City of Portland, Maine - Building or Use Permit

Permit No: 03-1472	Date Applied For: 12/03/2003	CBL: 124 DO08001
------------------------------	--	----------------------------

Proposed Use: build Handicap Ramp	Proposed Project Description: Build Handicap Ramp
---	---

Project No.: 020502012  
 Drawing Title: HANDICAPPED RAMP DETAILS  
 Date: 1/13/03  
 Sheet: 2 OF 2  
 AS NOTED

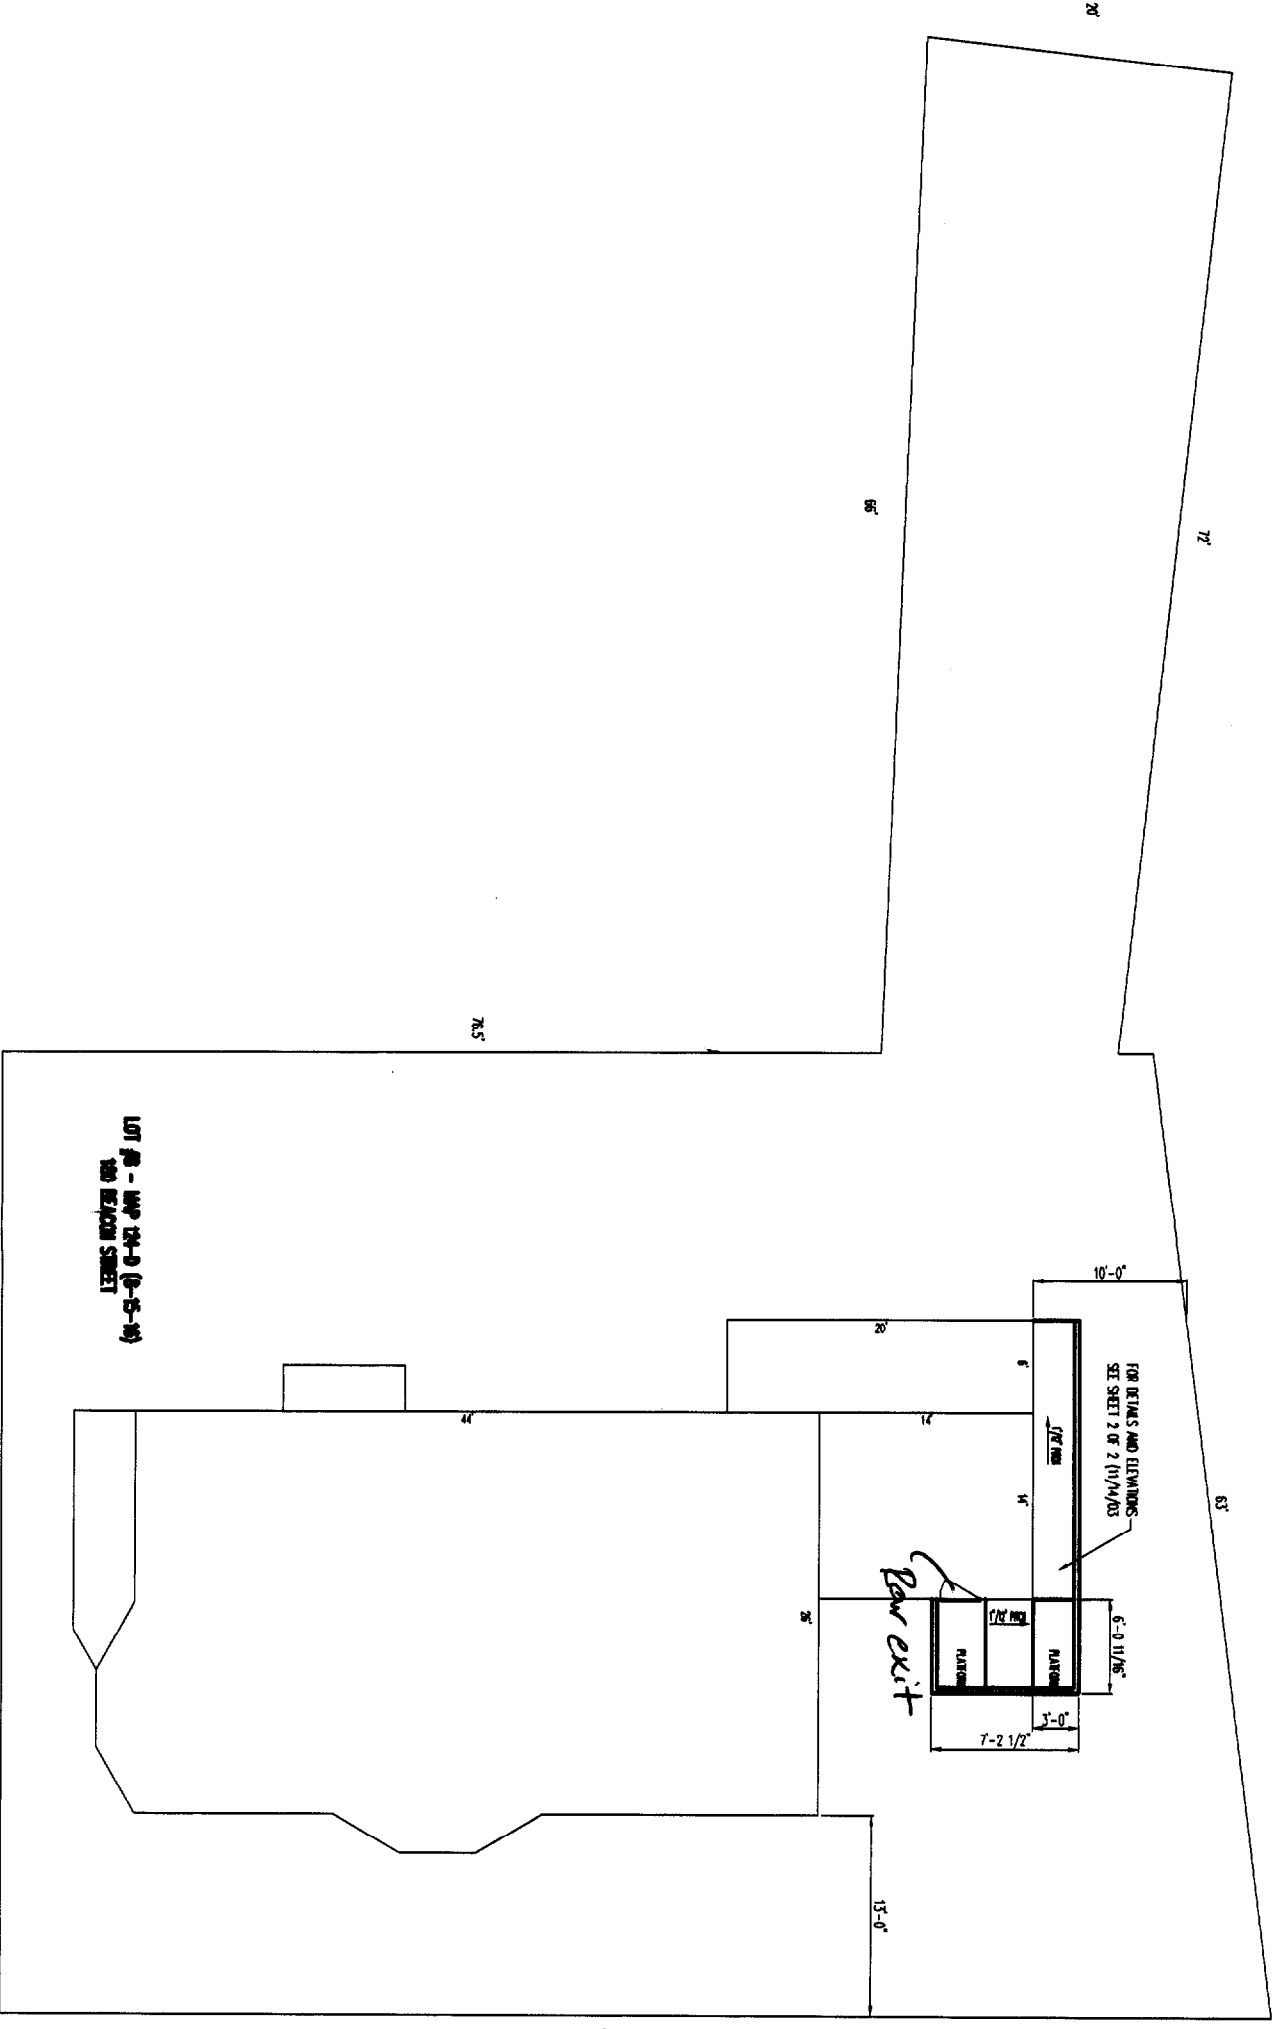
) The ramp shall remain detached from the structure and under 200sf so frost protection is not required
